Application No: FP/262/21/PL
Site Address: Mast at Felpham Way Bognor Regis PO22 8PS
Description of works: Erection of EE/H3G 15m High Phase 8 Monopole to replace existing EE/H3G 12.5m Phase 5 Monopole and associated ancillary works. This site is in CIL Zone 4 (Zero Rated) as other development.

Thank you for your internet representation made on 12th January 2022 which has been recorded as no objection with the comments as follows:

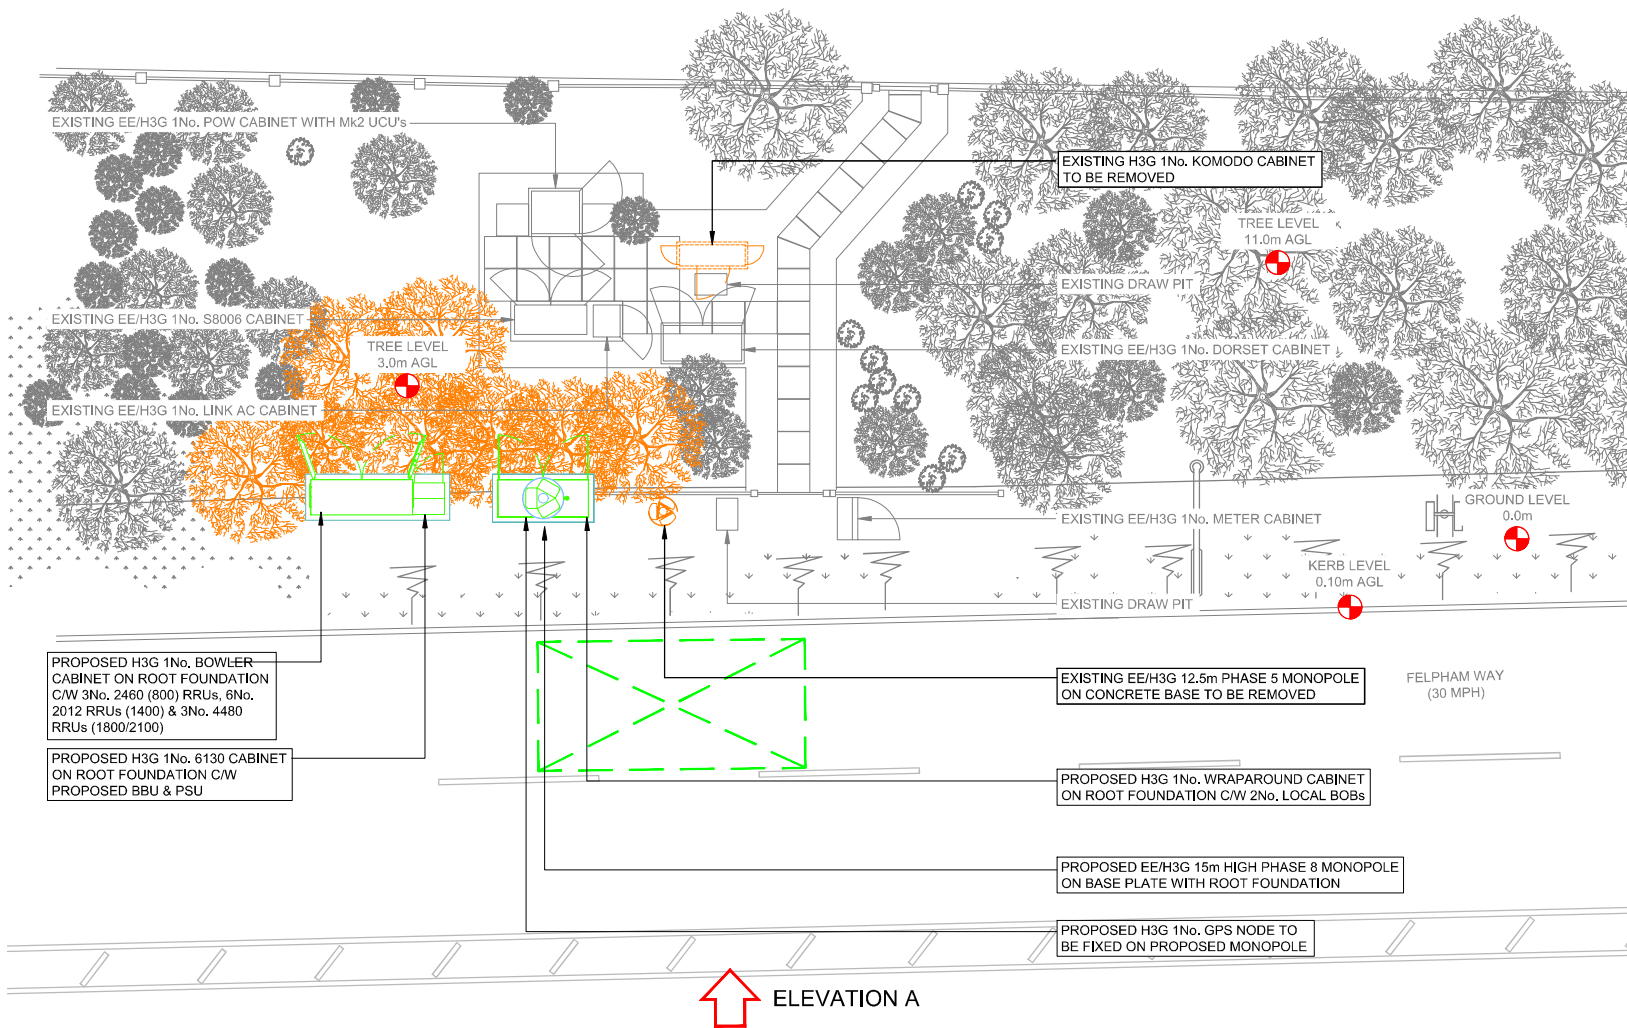
Felpham Parish Council would like to ensure that any removal of vegetation is sympathetic and retains the privacy of nearby residents.
